OBJECTION: MIXED-USE DEVELOPMENT MACKENZIE ST, LAVENDER BAY SSD-88702457

I am the owner and resident of 12 Wilona Avenue, Lavender Bay. My home is an early 1900s single storey terrace and is identified as a contributory item within the Lavender Bay Heritage Conservation Area, it is directly across the road from the development site and is one of the properties most immediately affected by the proposed development.

SHADOW
ANALYSIS
REVIEW

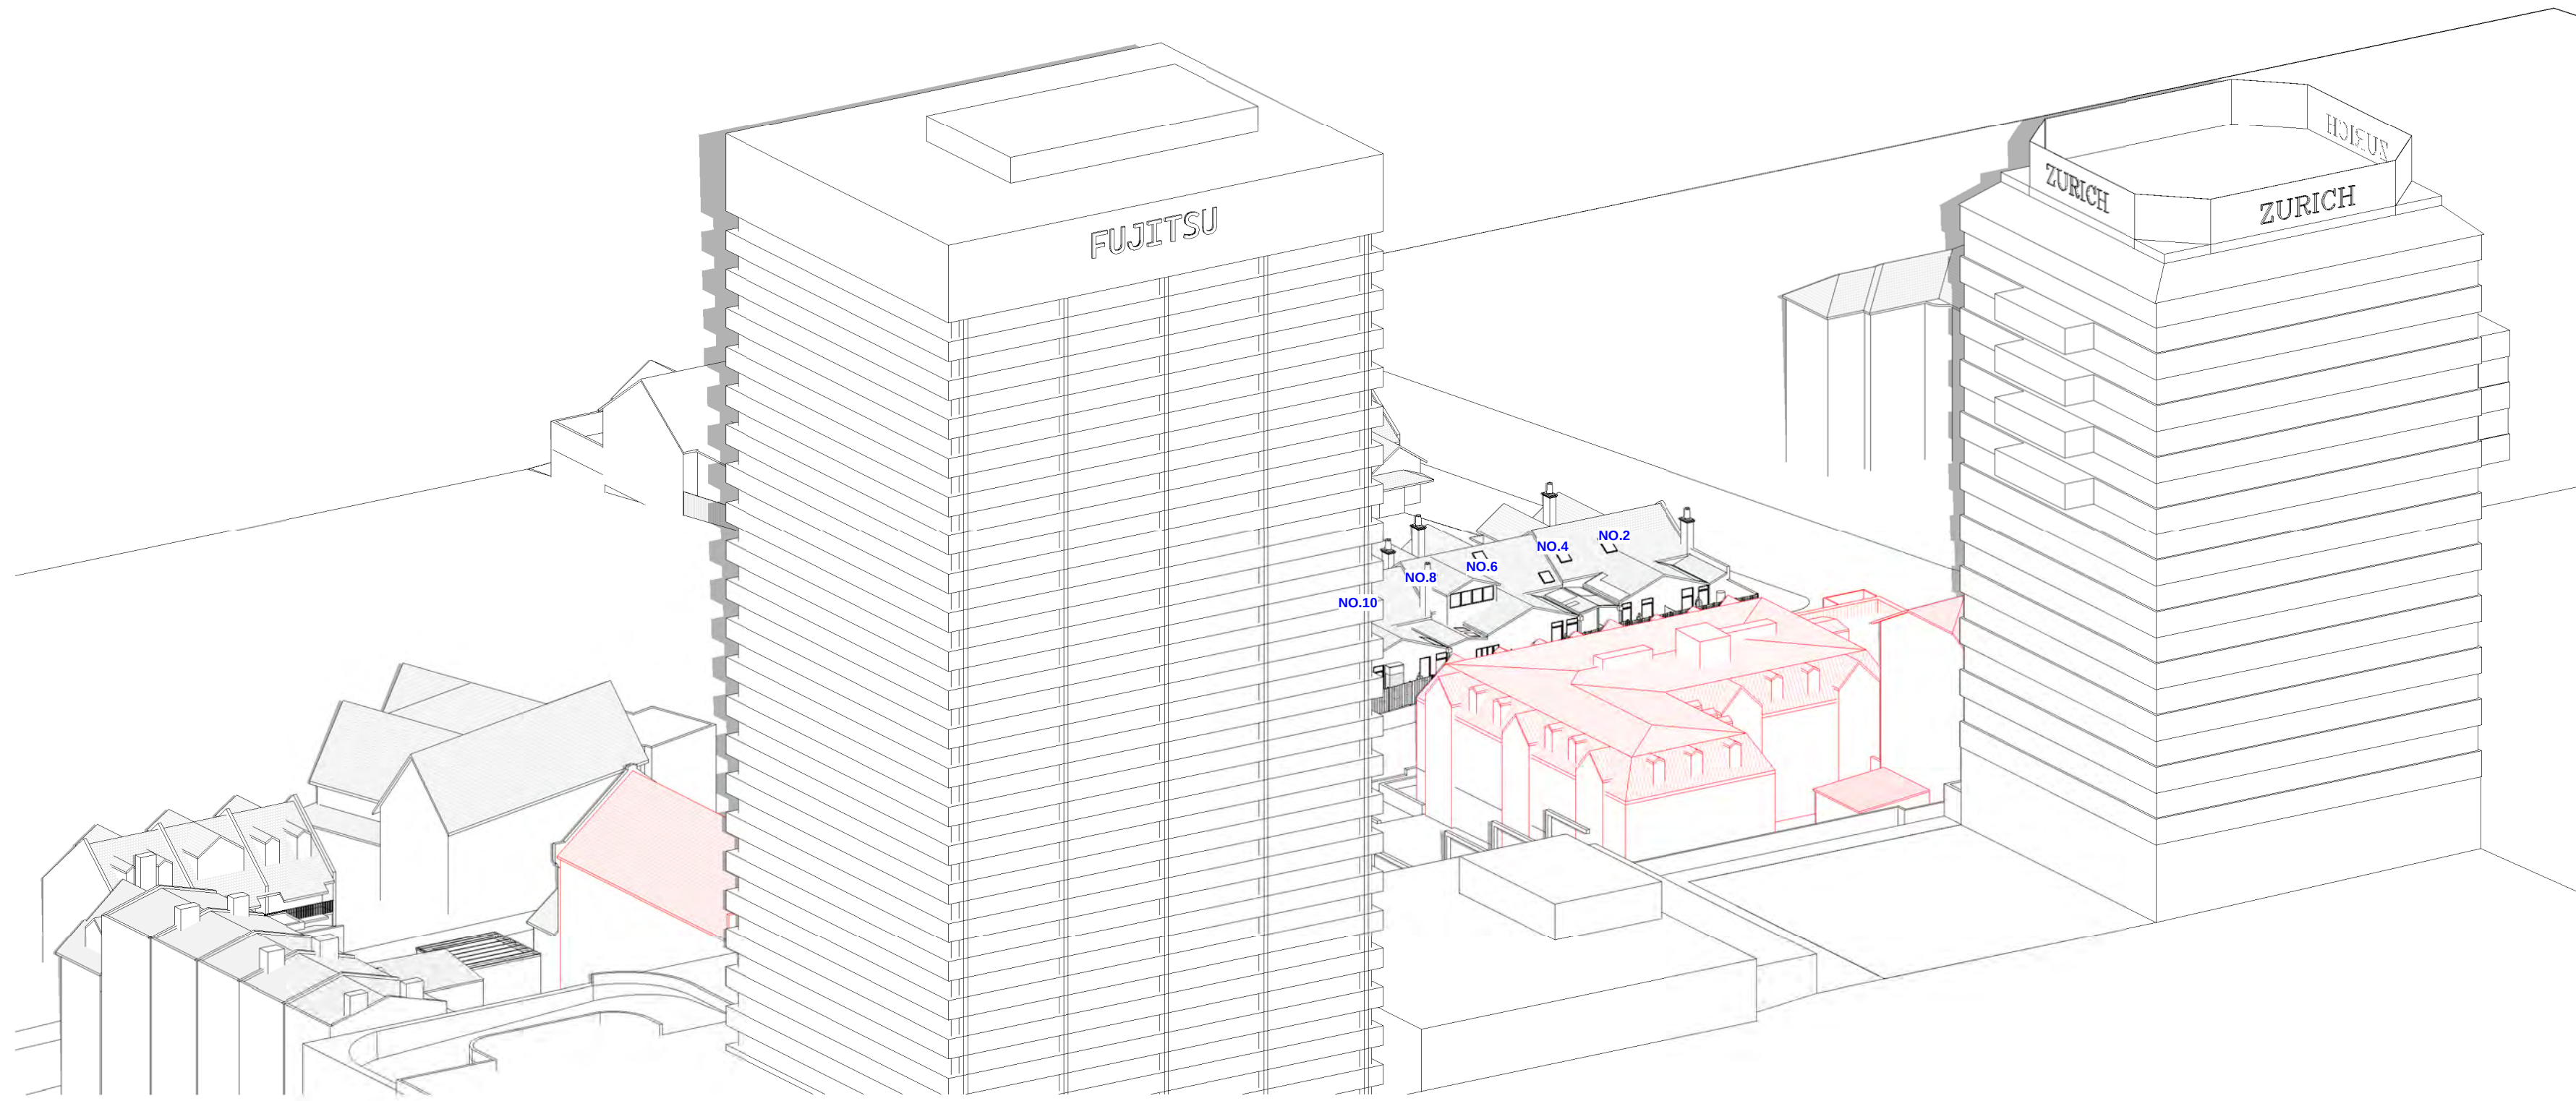
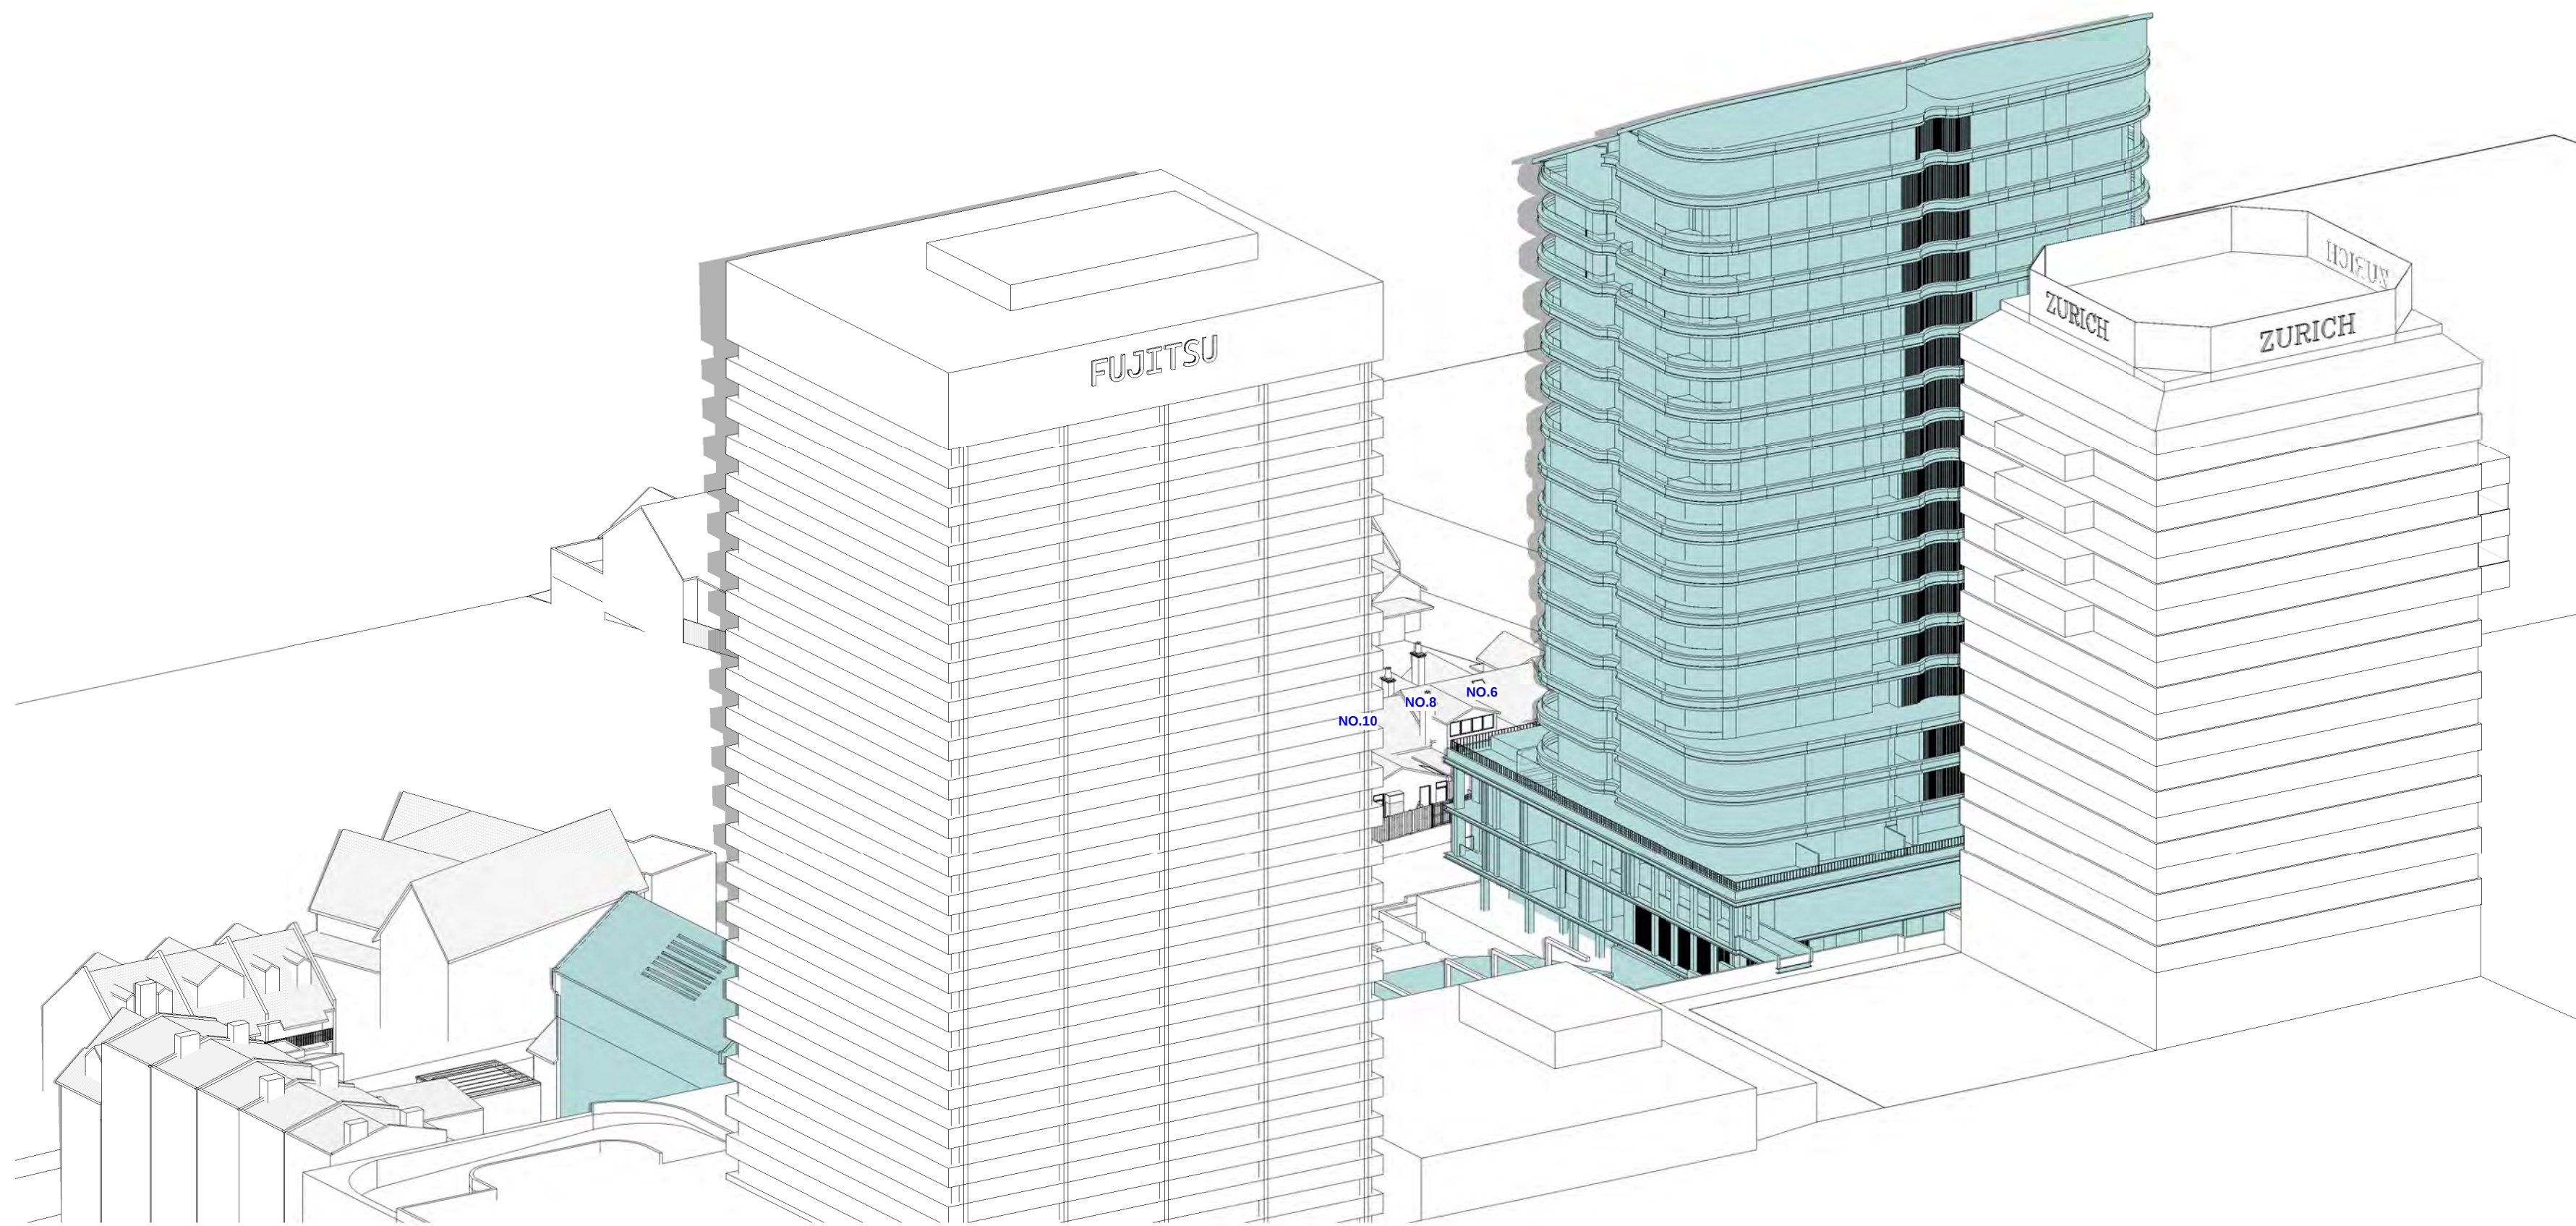
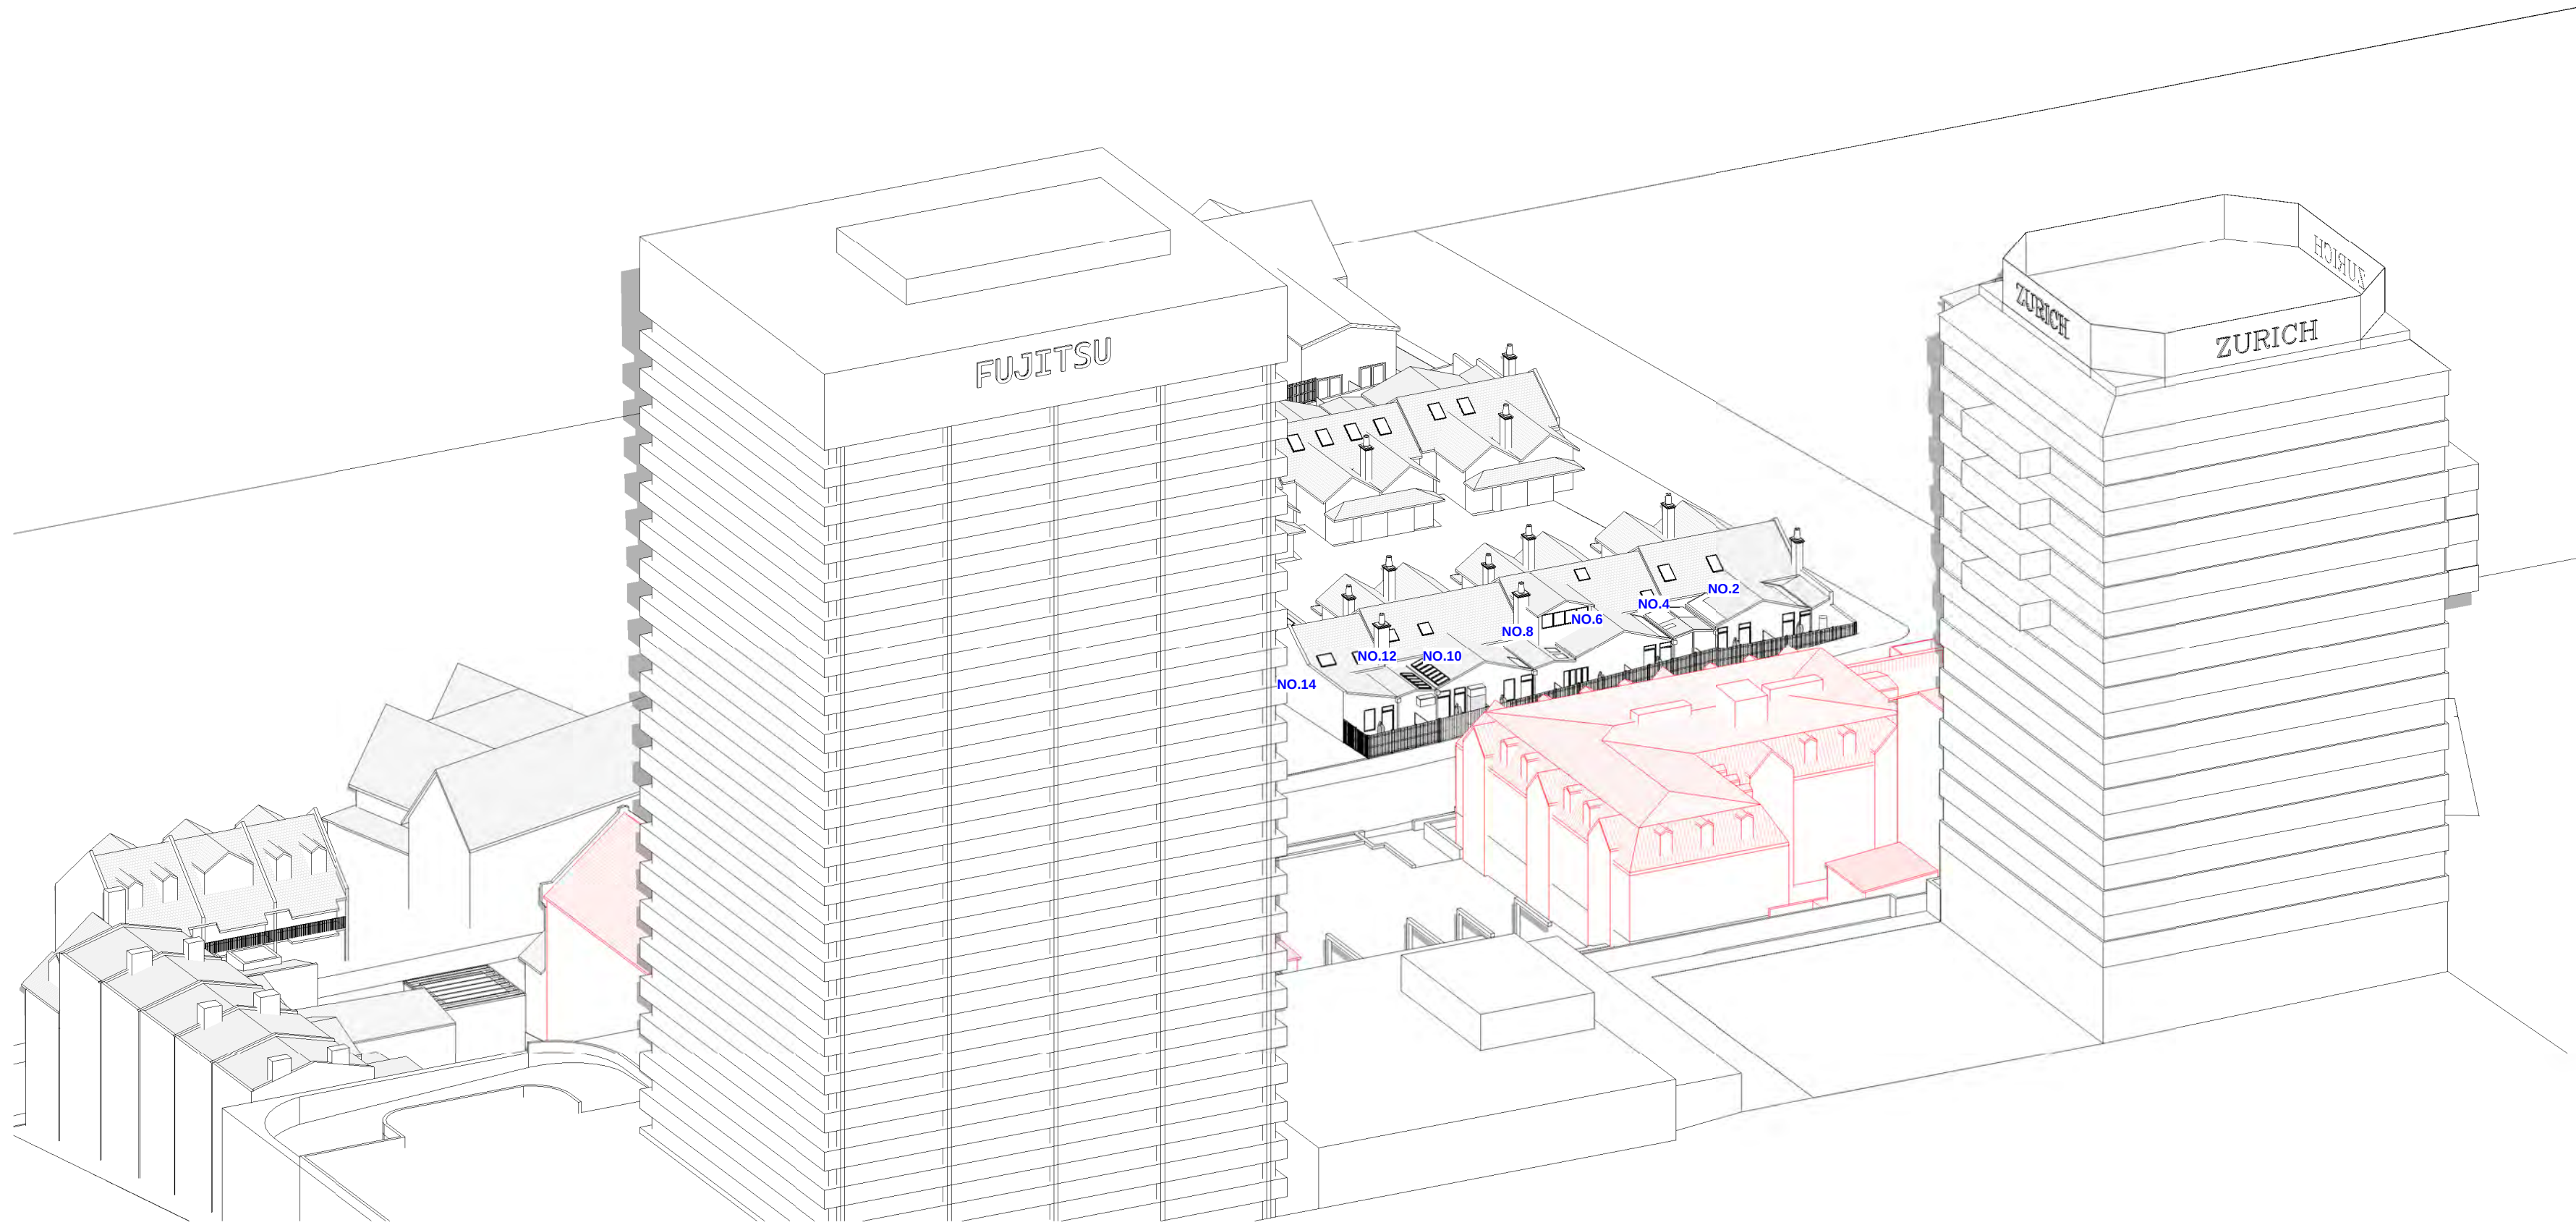
The applicant's solar assessment is not a reliable basis for determining what this proposal will do to my home and it does not show the real impact. It does not make any assessment of the solar impact on my home, assuming incorrectly that we currently have no solar access therefore disregarding the impact. It also omits the existing solar panels on my roof. My independent analysis looks at the actual openings to my home, hour by hour, and compares existing solar access with what will remain after the development. The result is clear: substantial existing sunlight will be taken away.

Most importantly, the applicant's own overshadowing diagrams demonstrate that the severe solar impacts identified above are not an inevitable consequence of redevelopment of the site. Appendix L shows that development within the existing planning controls would cause substantially less additional shadow and only minimal overshadowing of the Wilona Avenue terraces and my home.
